# Elevations\_v1-redline.pdf Markup Summary

BD 2

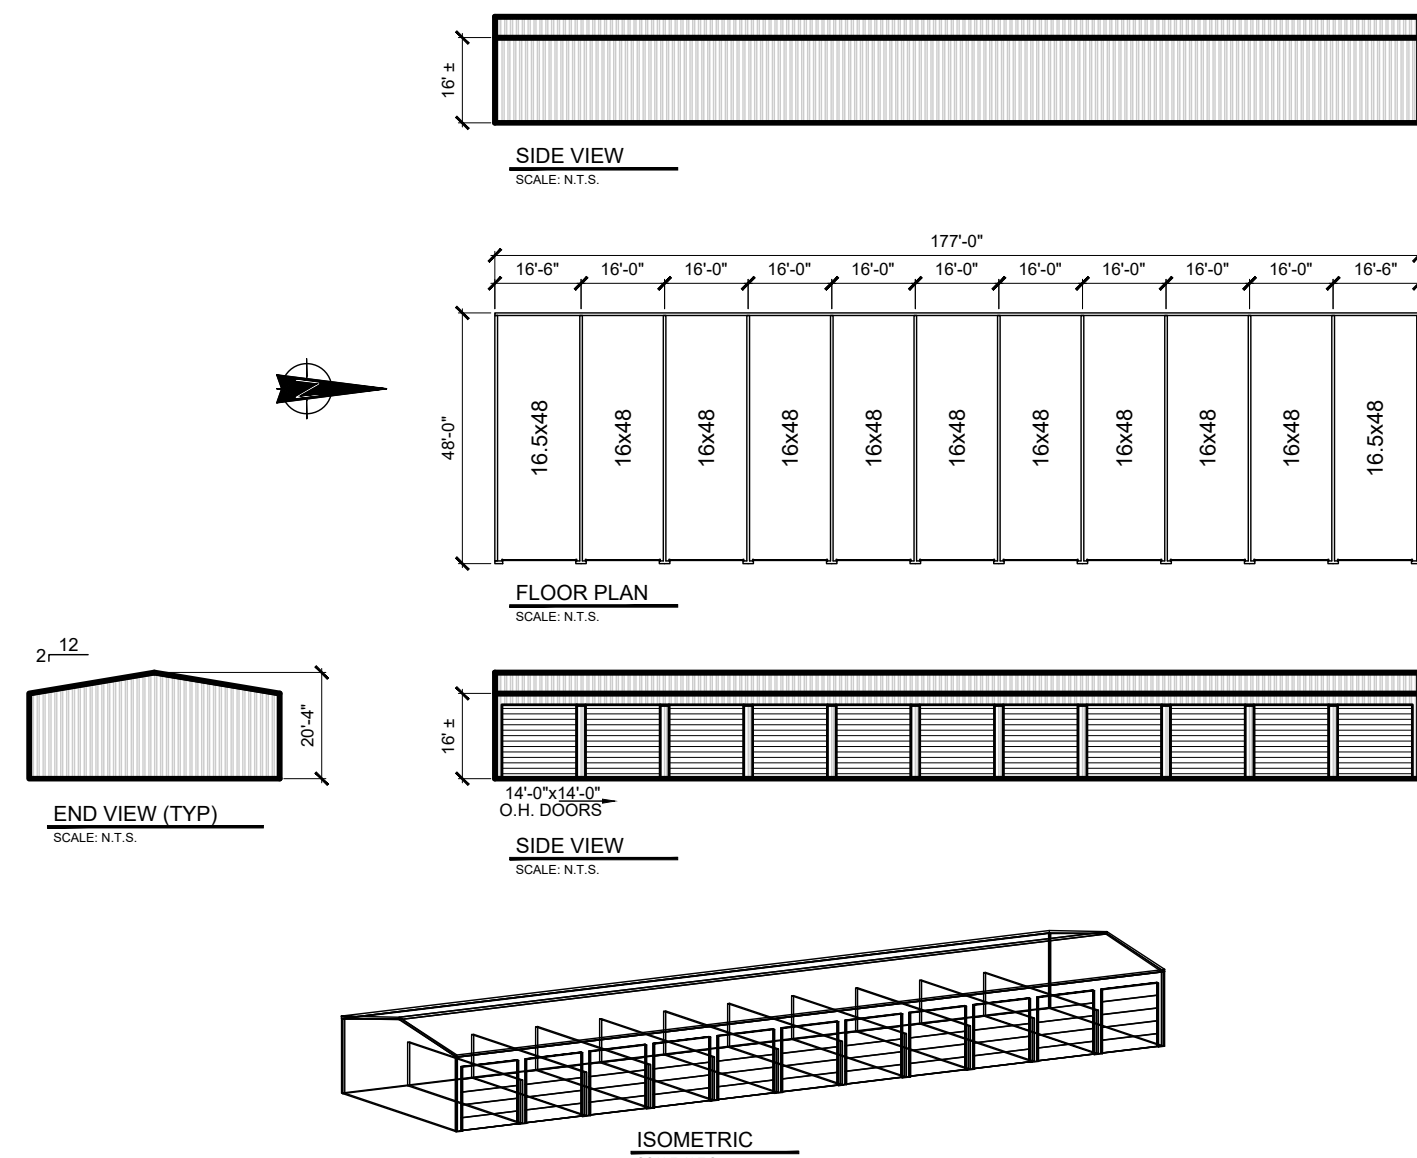
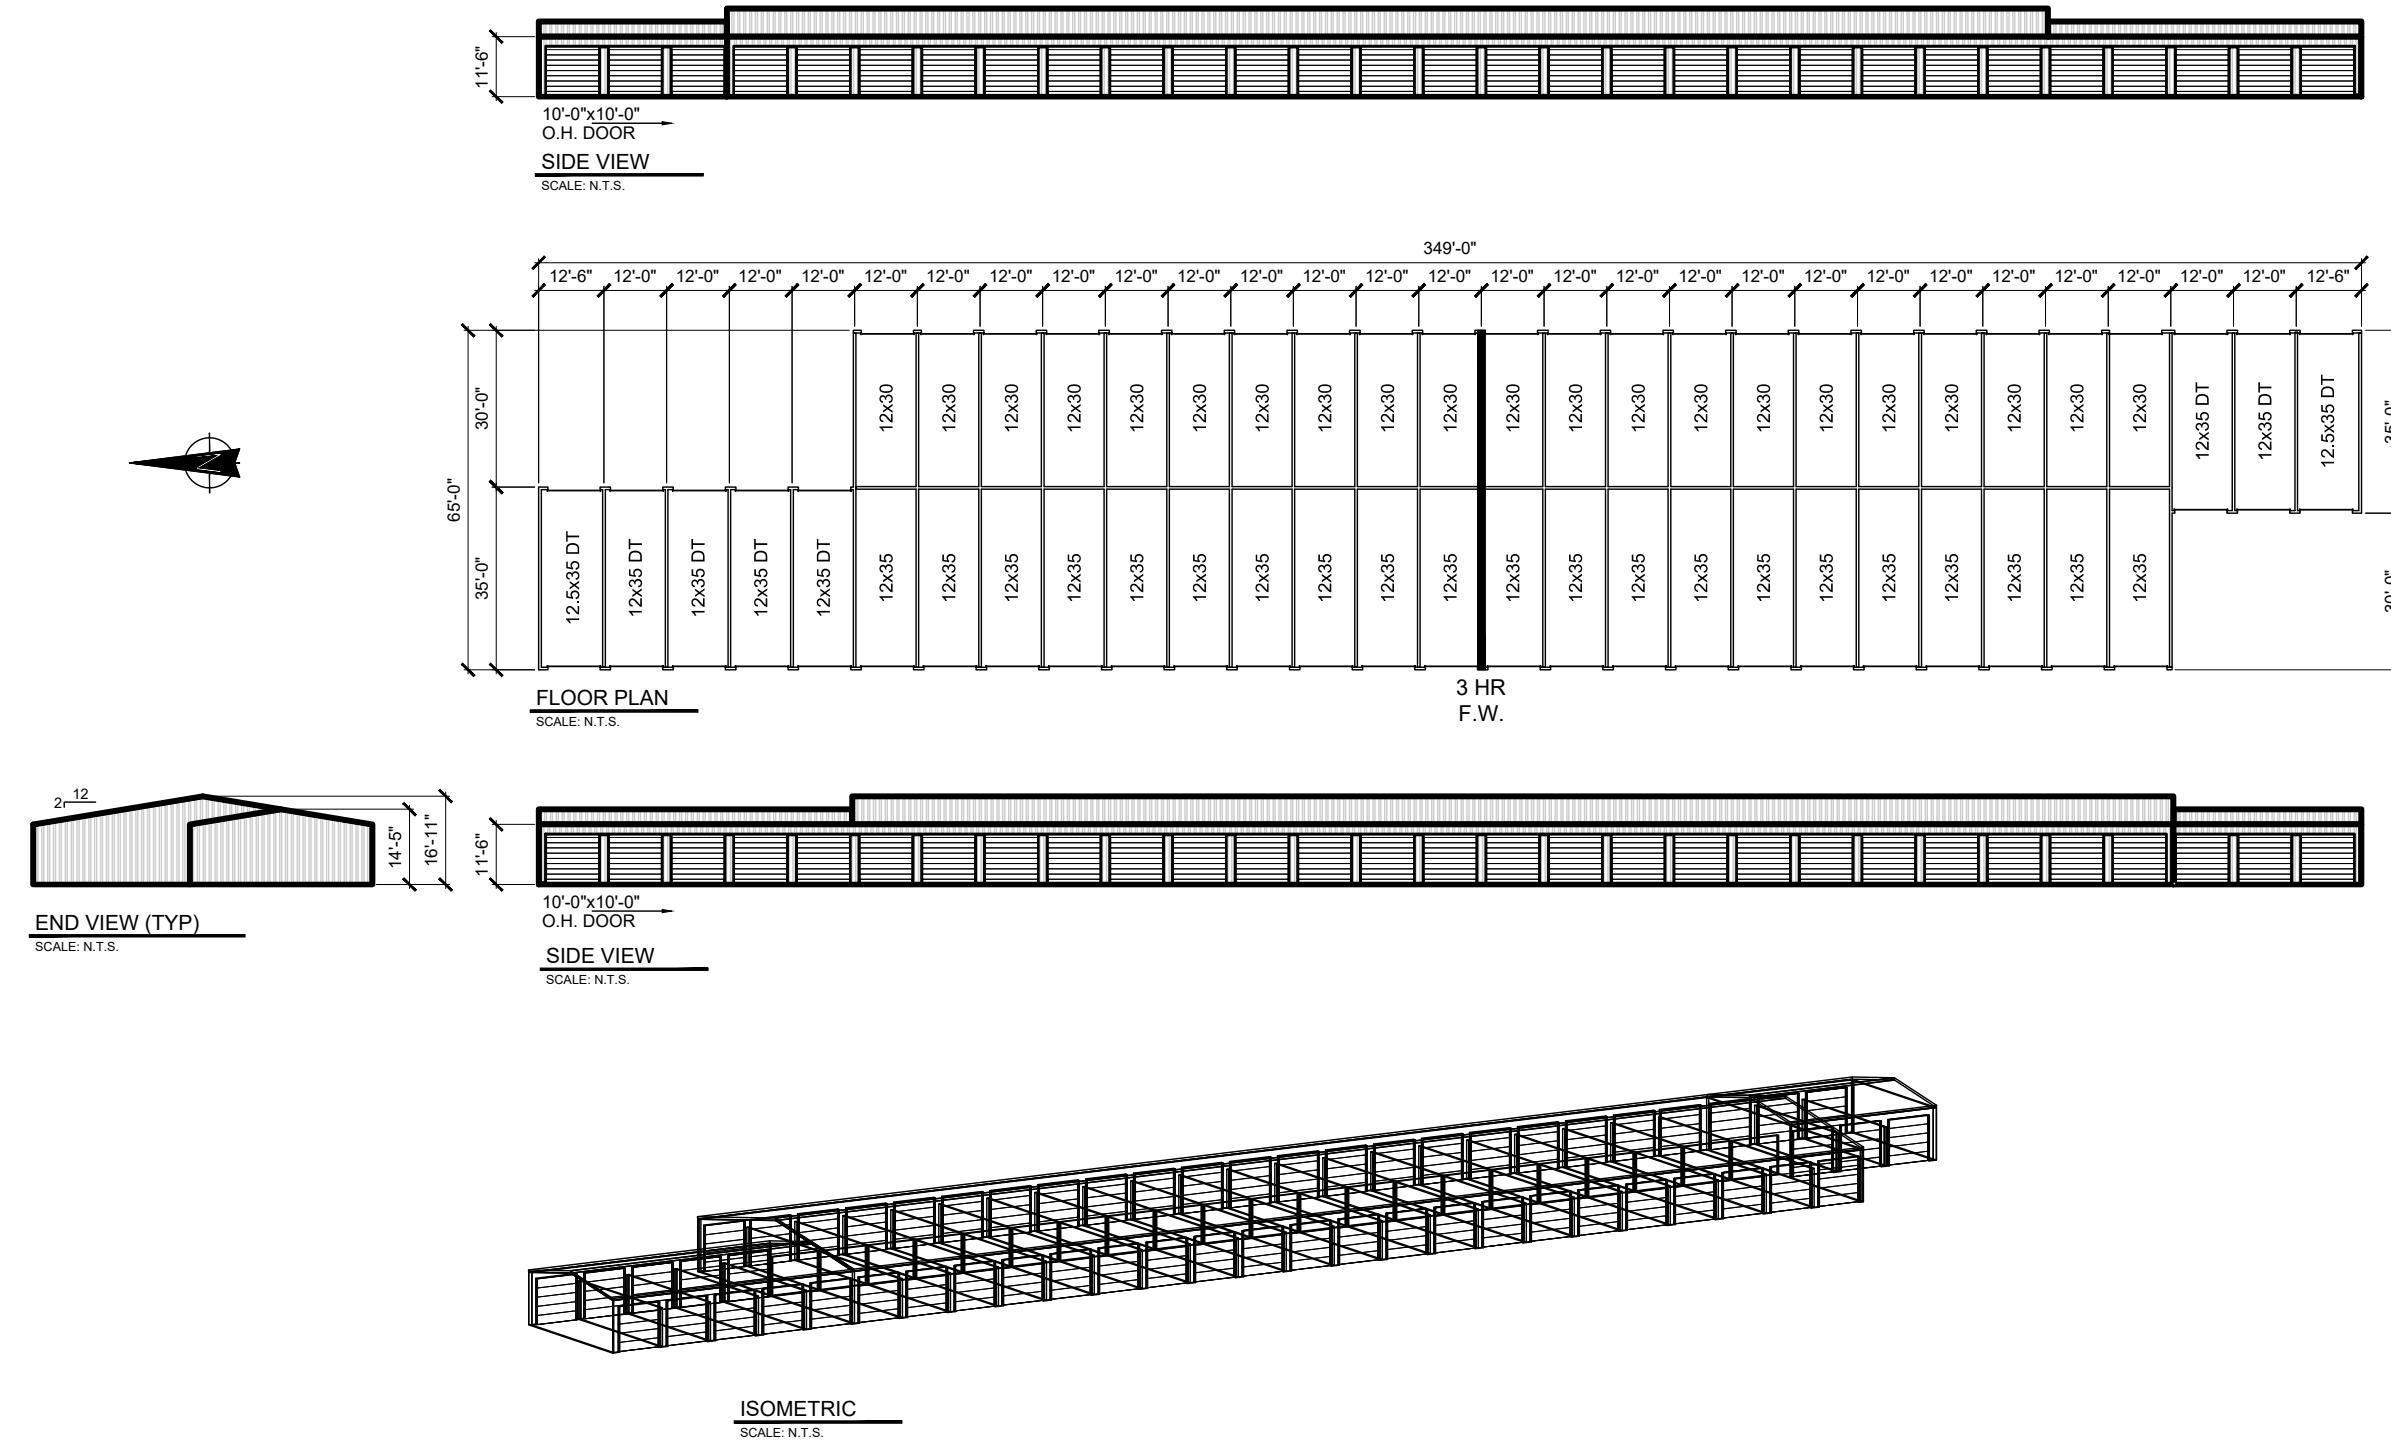
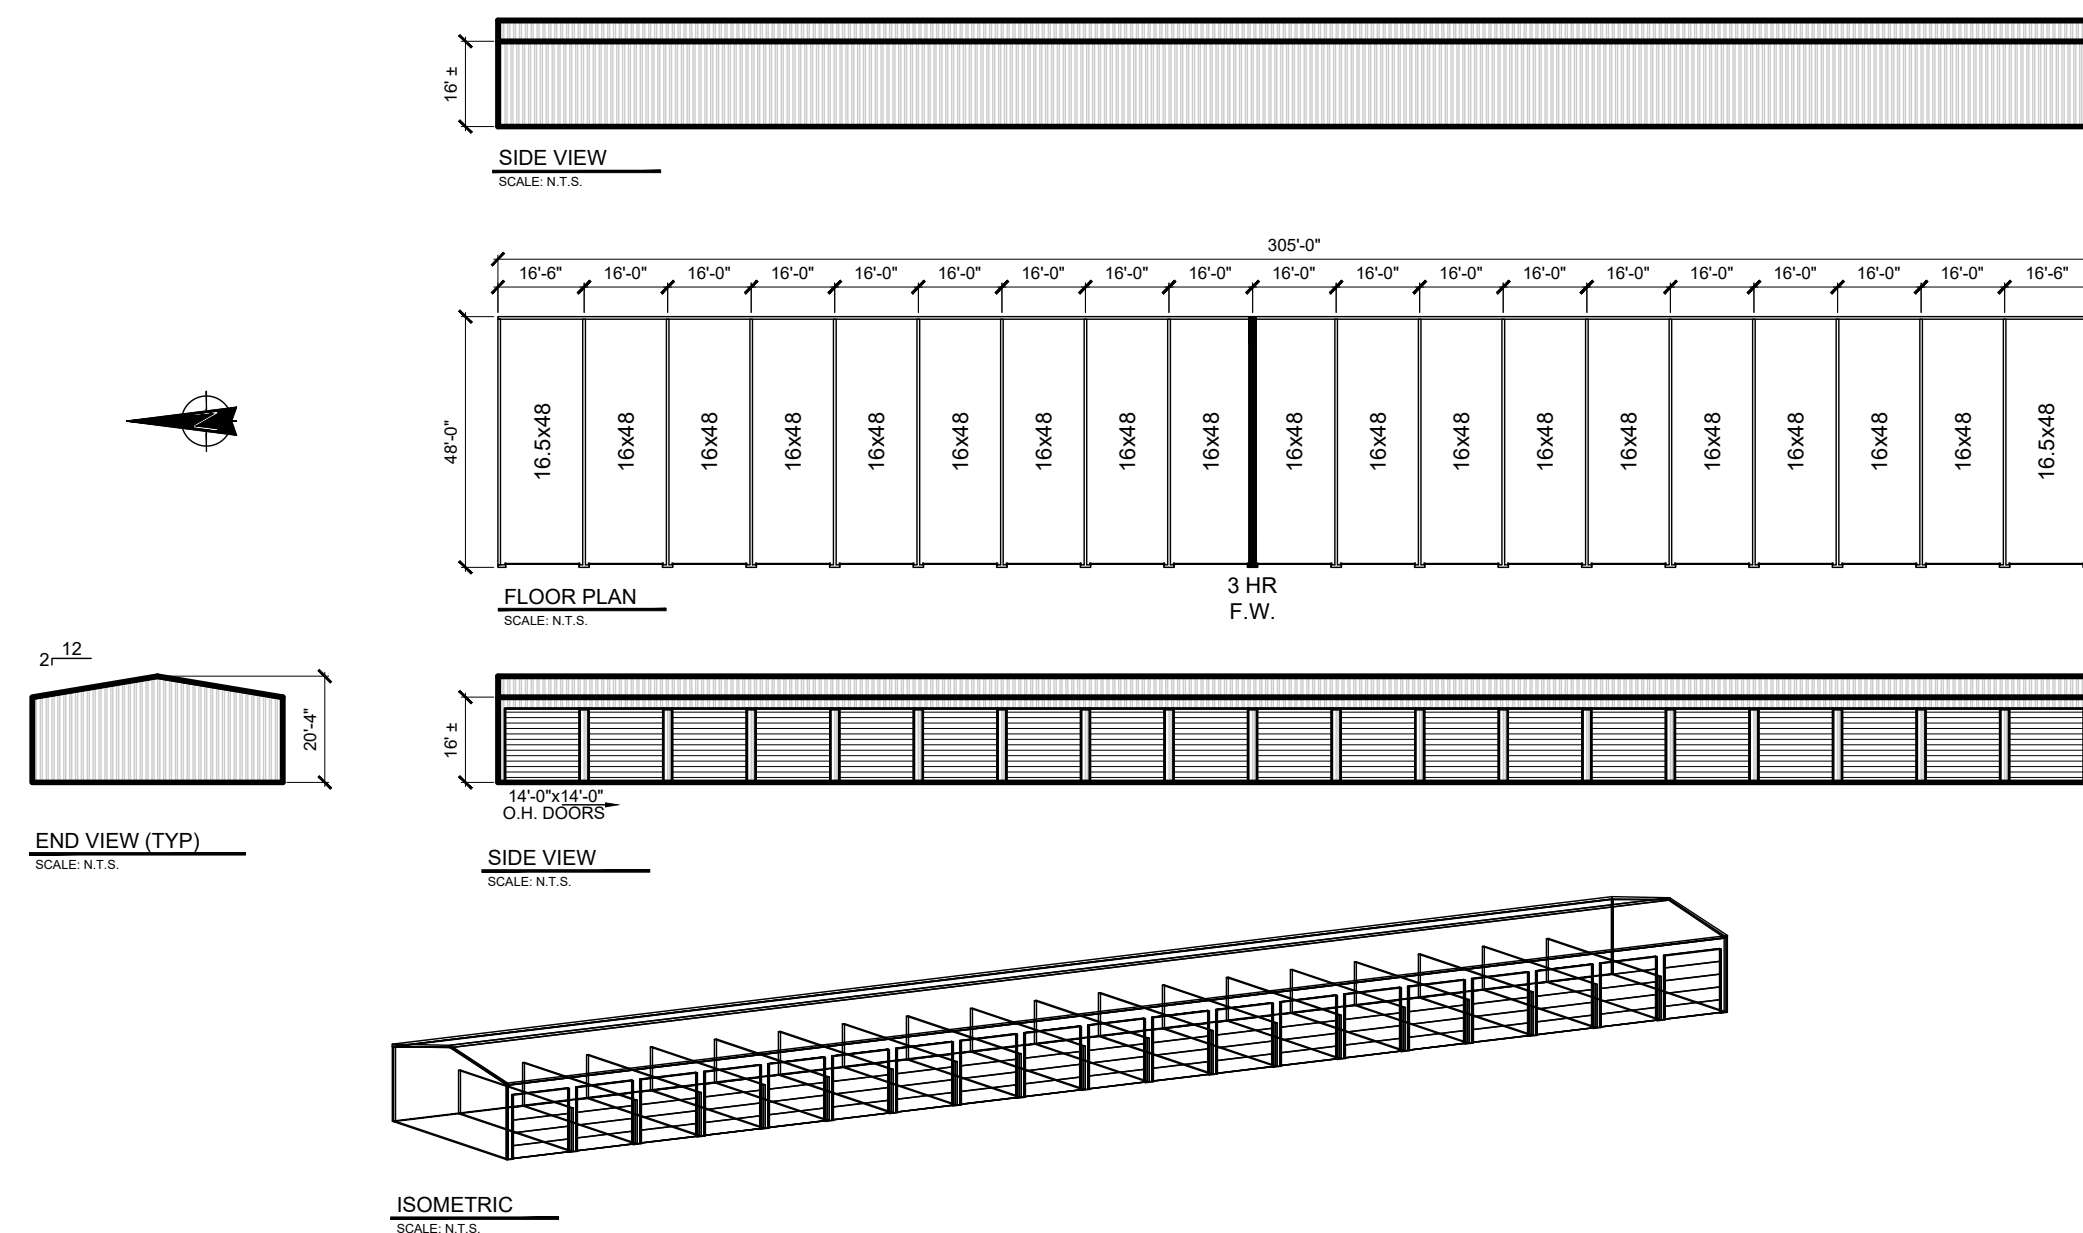
Show heights of structures (1)

Show heights of structures

Show heights of structures
